Application No: 19/00214/DISC

Proposal: Partial discharge of conditions 13 (positioning of bicycle and bin stores), 24 (design and construction details), 25 (final surface treatment), 31 (landscape design), 53 (site levels) and 84 (ecological construction method statement) of 10/01780/HYBRID

Location: Bicester Eco Town Exemplar Site Banbury Road Bicester

Transport Development Control

**Boardwalk Construction  
Details**

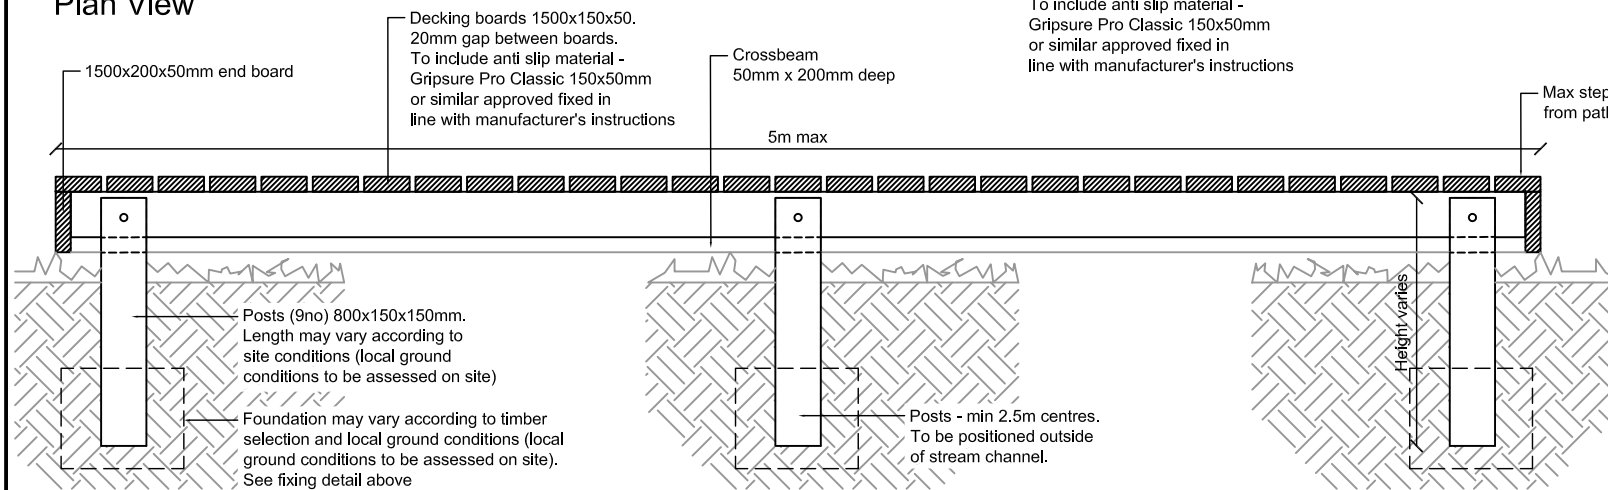
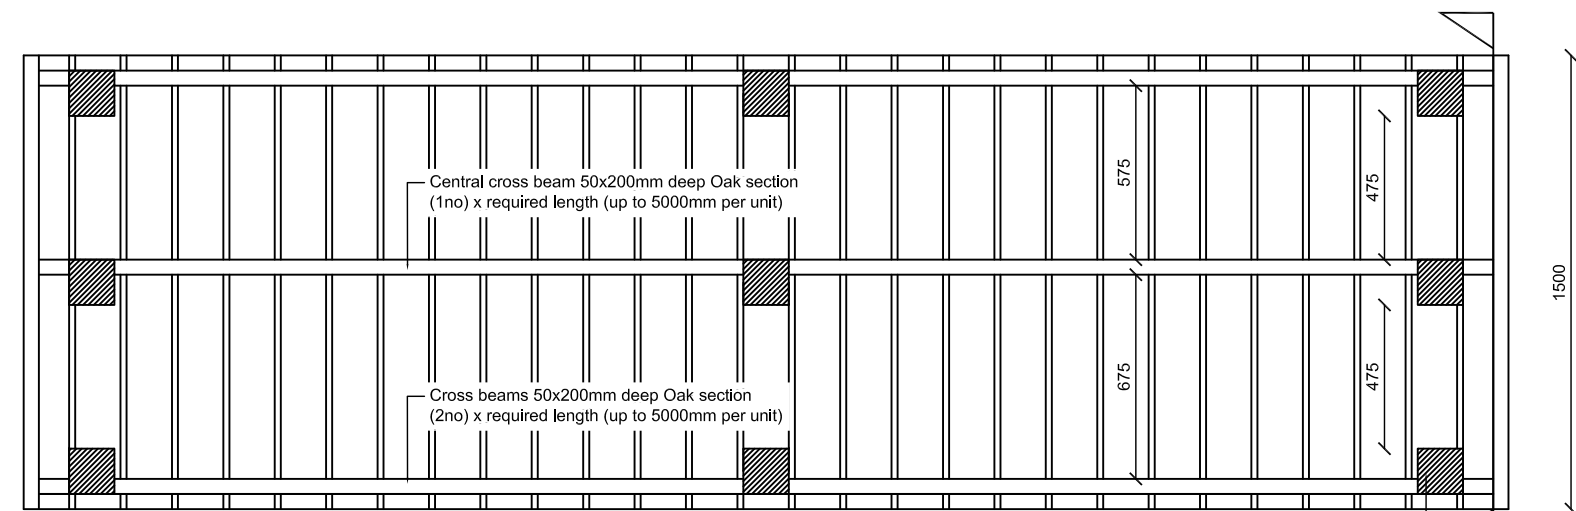
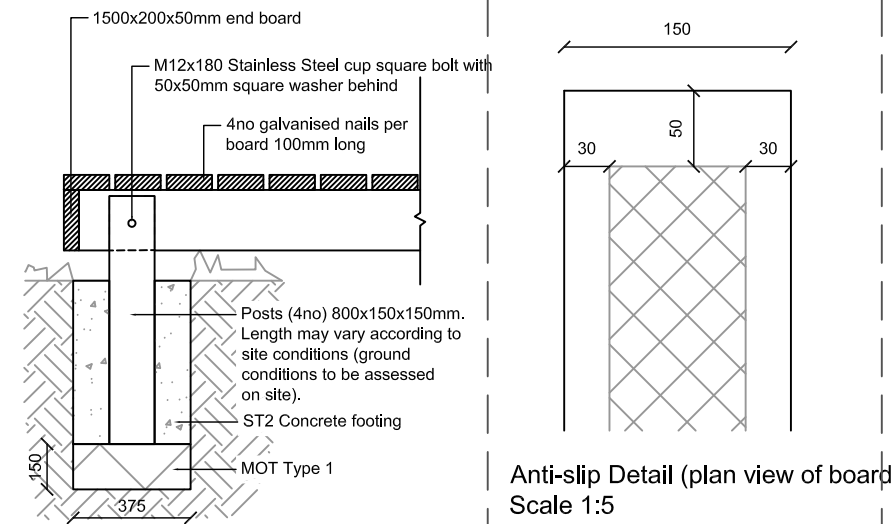
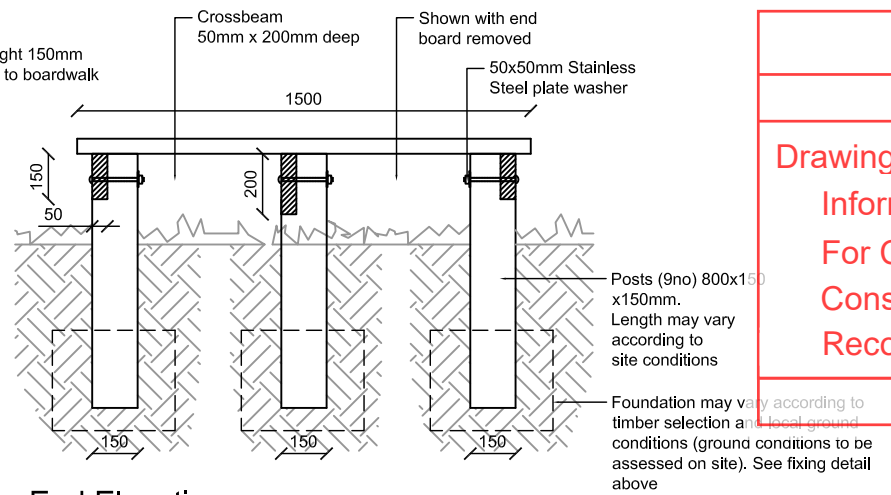
Condition 13 and 24 – No objection to partially discharge conditions 13 and 24 of 10/01780/HYBRID. The relocation of the sheffield stands is found acceptable and the details of the board walk along the river corridor is sufficient for development.
